Application Ref:	3/2026/0362			 Ribble Valley Borough Council www.ribblevalley.gov.uk
Date Inspected:	19/06/2026	Site Notice:	N/A	
Officer:	AR			
DELEGATED ITEM FILE REPORT:				APPROVAL

Development Description:	Planning Permission for existing single storey rear extension and front porch.
Site Address/Location:	12 Fairsnape Avenue Longridge Lancashire PR3 3TL

AS-BUILT ELEVATIONS

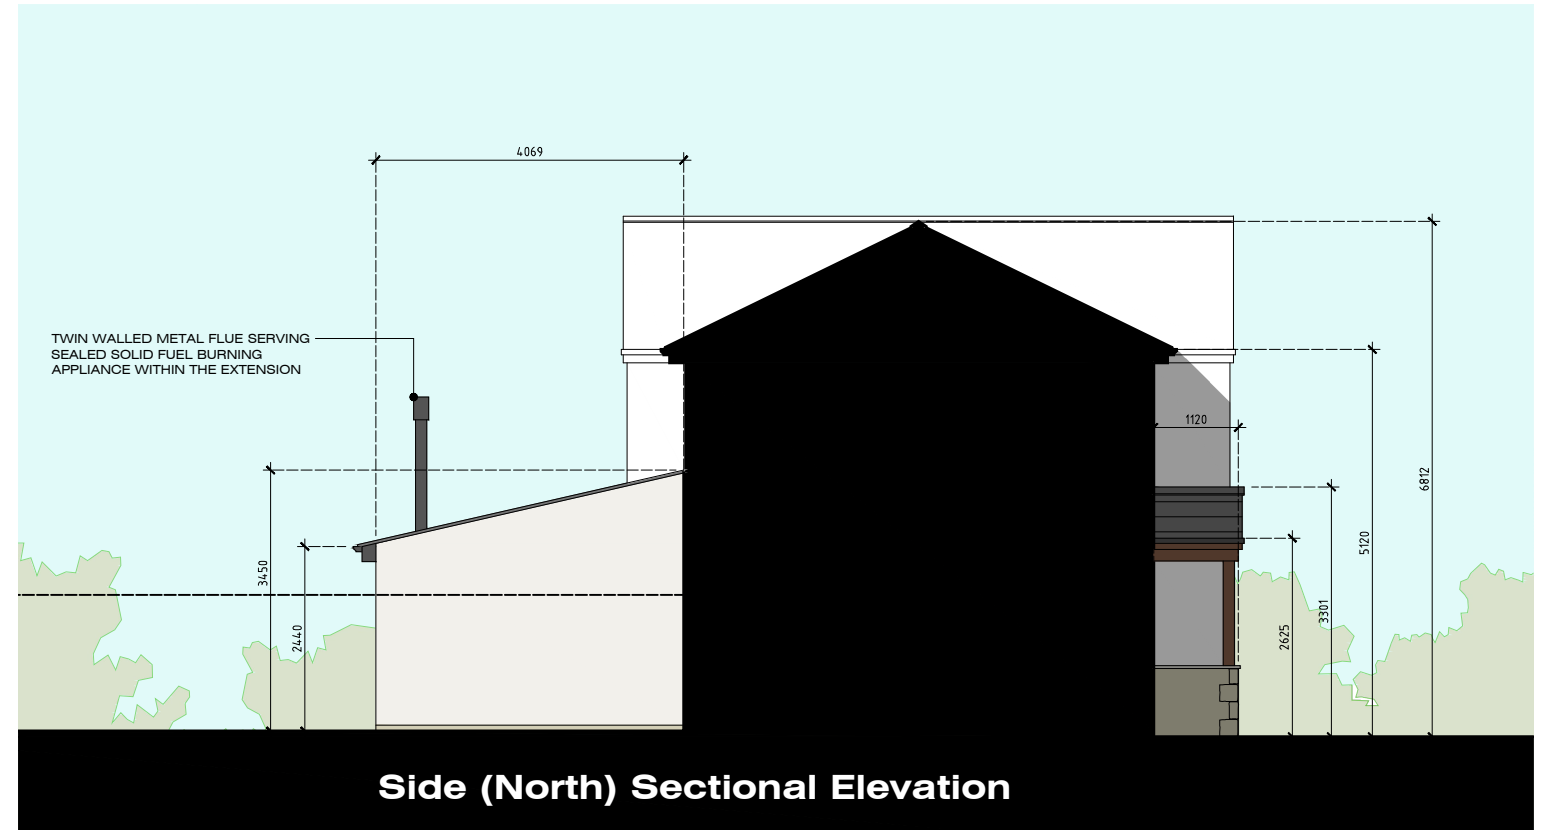
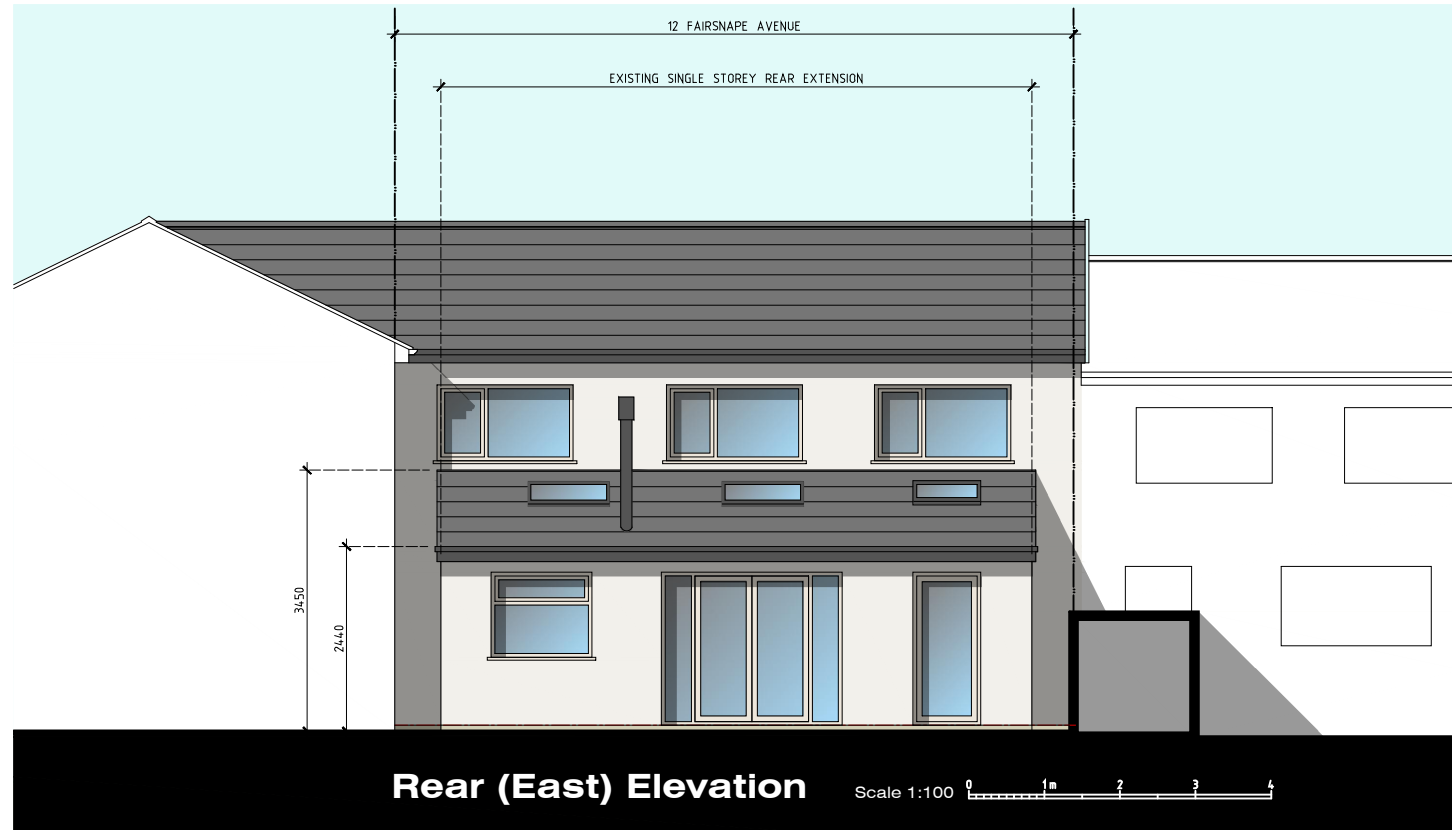
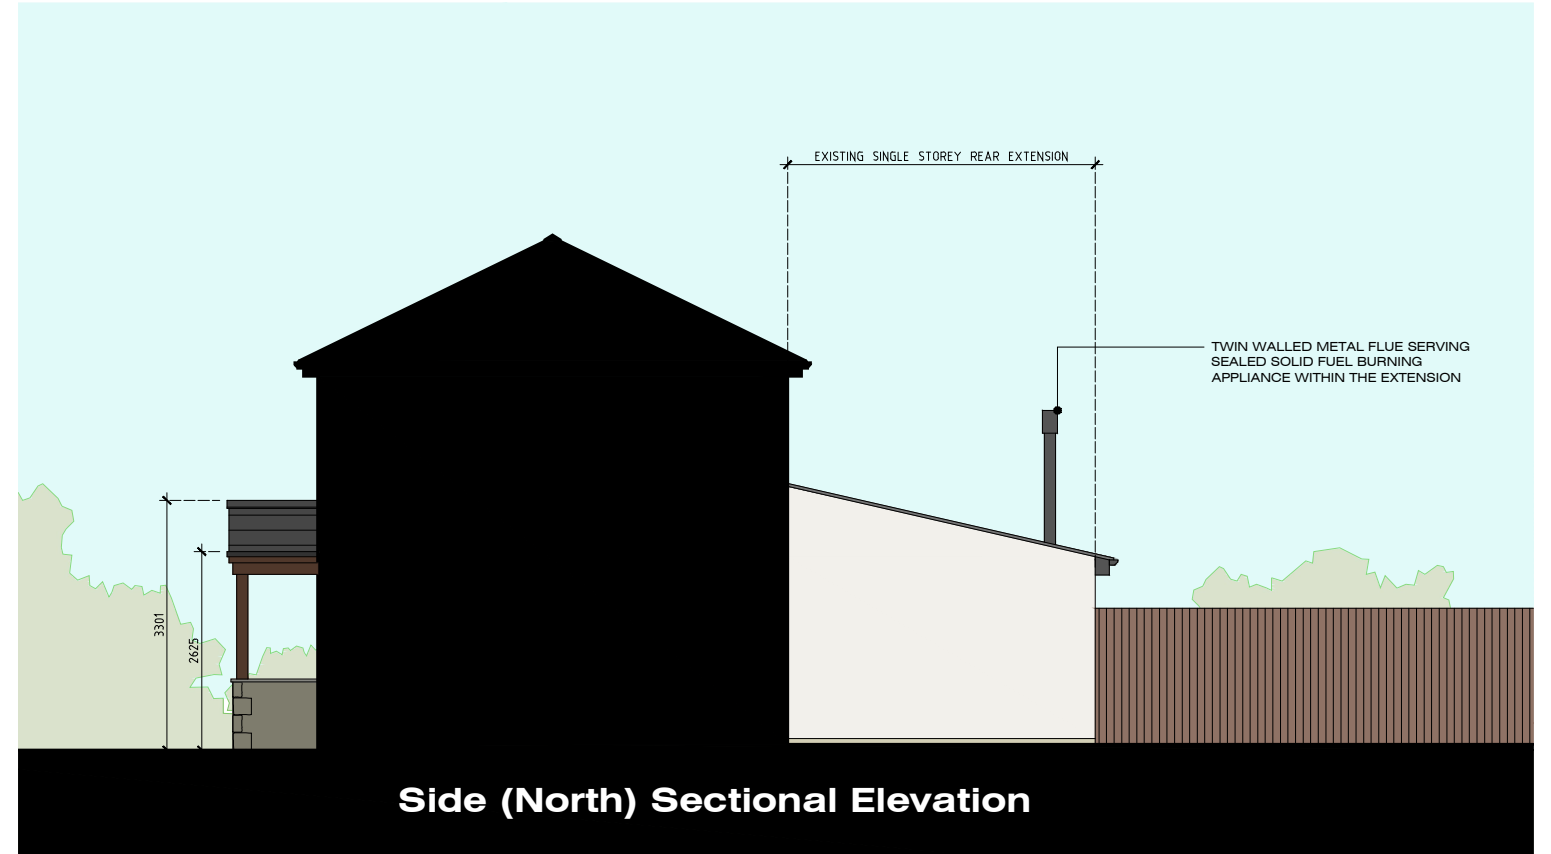
In terms of scale, the extension has a moderate footprint, measuring approximately 4.06m in length and 7.81 m in width, with eaves and ridge heights of 2.44m and 3.45m, respectively. As such, the extension will match the architecture of the dwelling house and neighbouring dwellings and would not be read as an incongruous addition to the application site.

With regard to materiality, the rear extension features off-white render walls, interlocking concrete roof tiles, off-white UPVC windows and doors, black UPVC guttering and downpipes, and black UPVC-clad fascias and soffits, all to match existing.

The front porch features a concrete footing, a stone wall rising to 0.9m above ground floor level, and a timber structure constructed from European oak, with fascias and gutters. Whilst the front porch could have been designed more appropriately in terms of materials to ensure visual integration with the wider street scene, its modest footprint and simple design mean it does not represent an overbearing or dominant structure and can be considered an acceptable addition to the dwelling house.

# AS-BUILT SITE PLAN

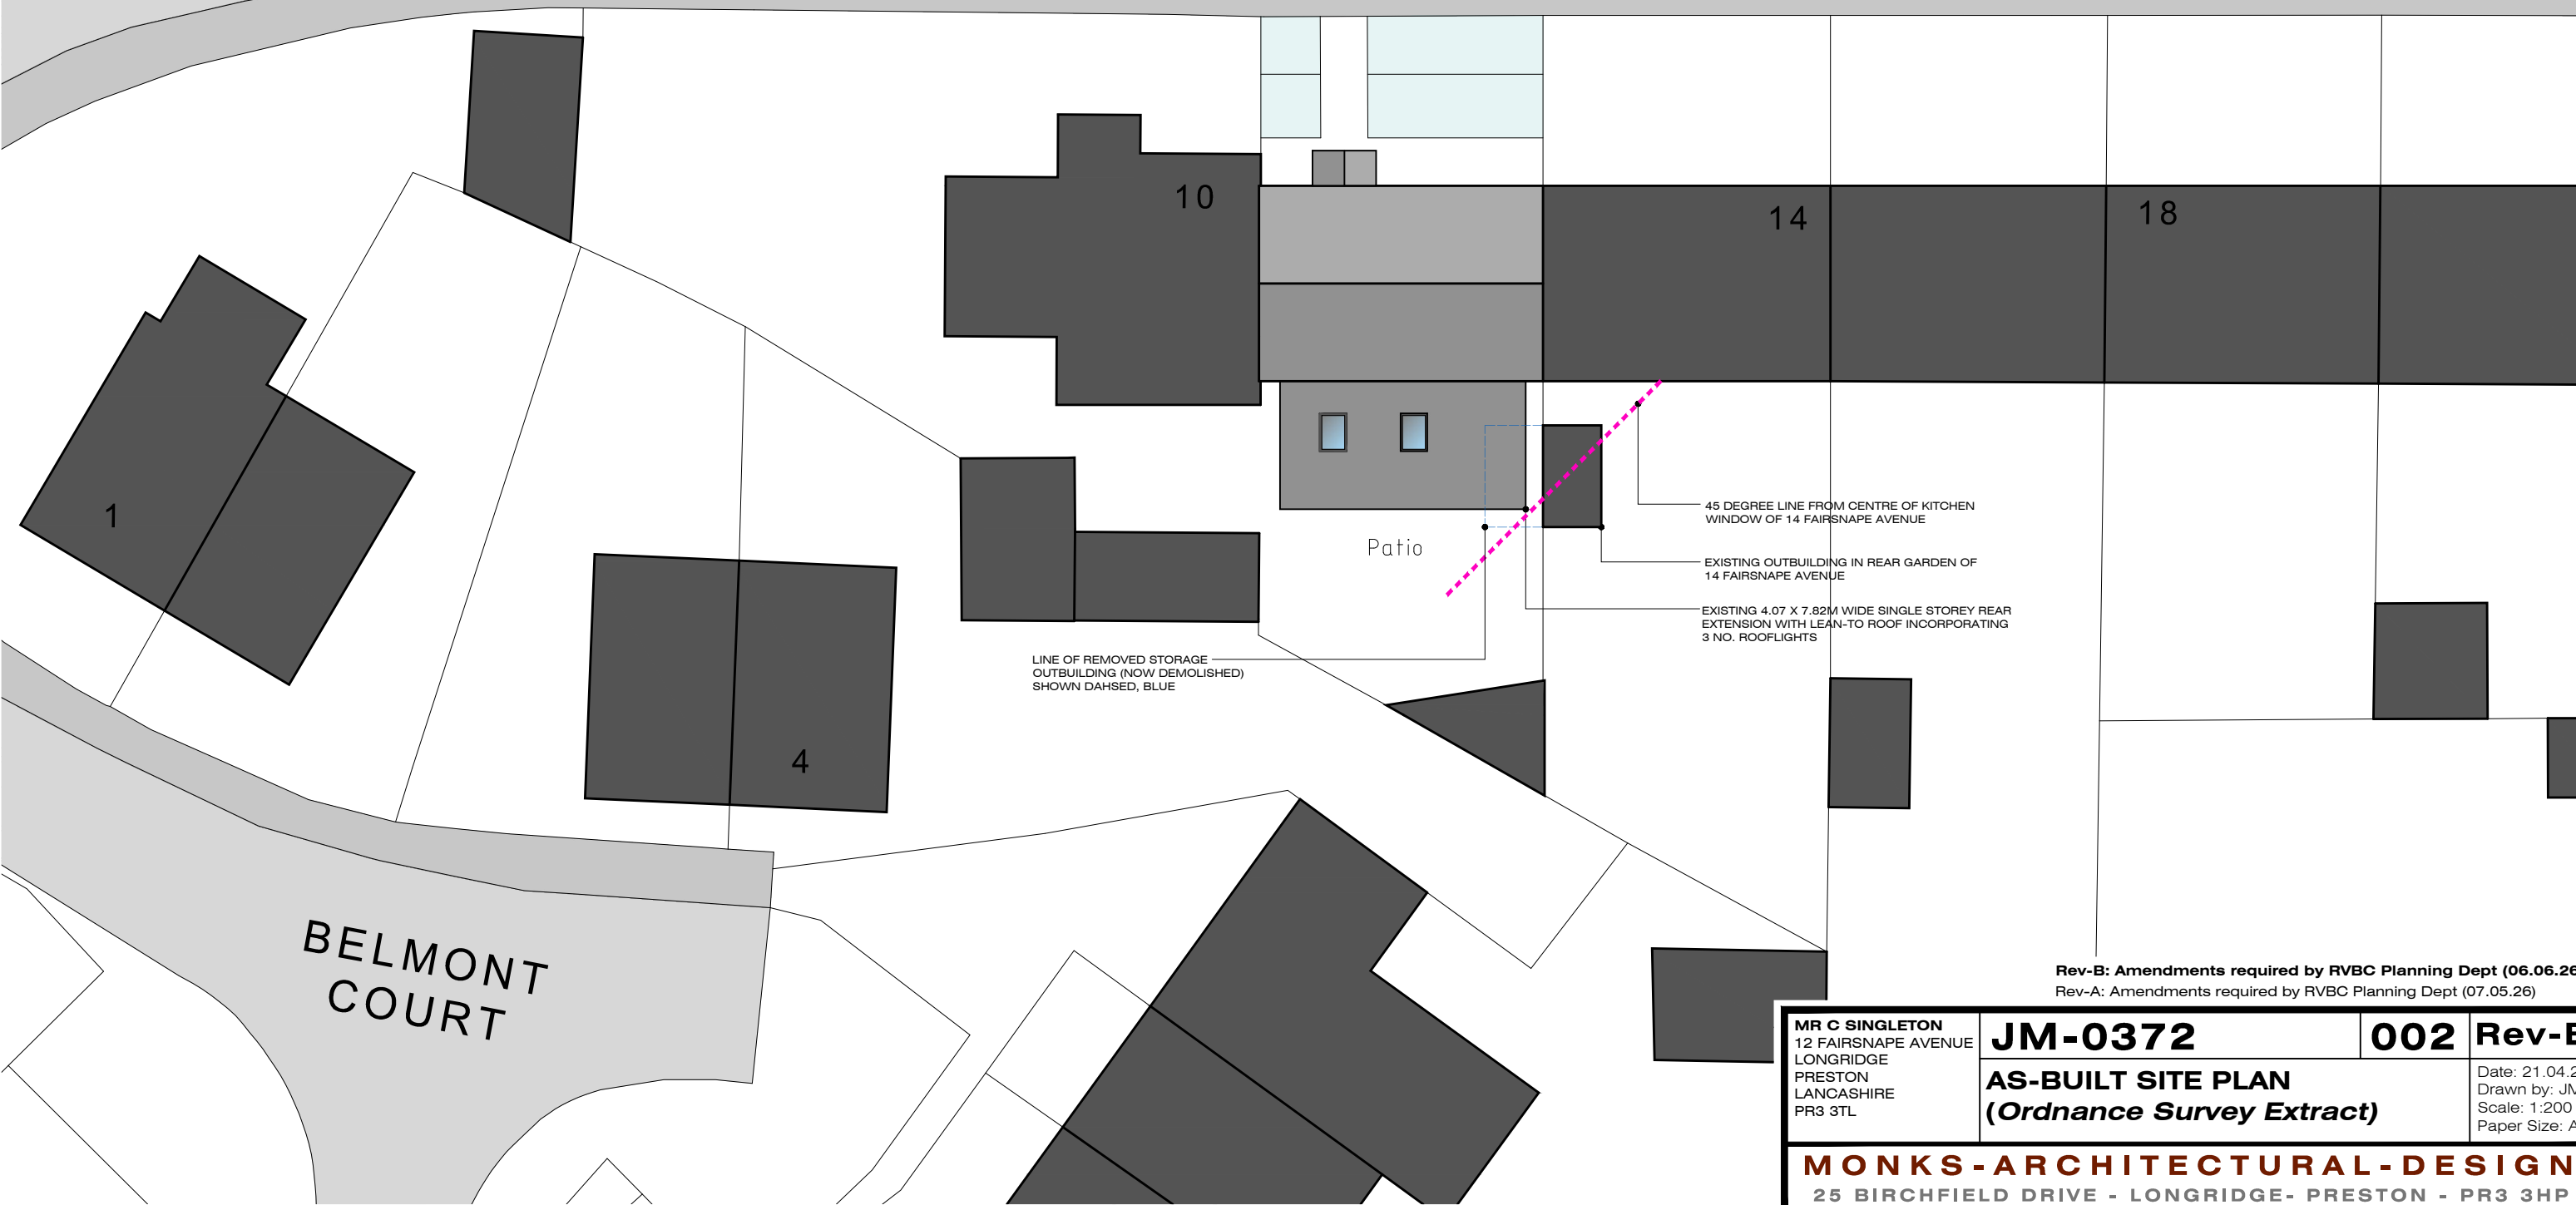
Furthermore, with respect to the impact on No.14 Fairsnape Avenue to the north, the submitted site plan demonstrates that the extension does not breach the 45-degree line drawn from the centre of the nearest habitable room window at No.14.
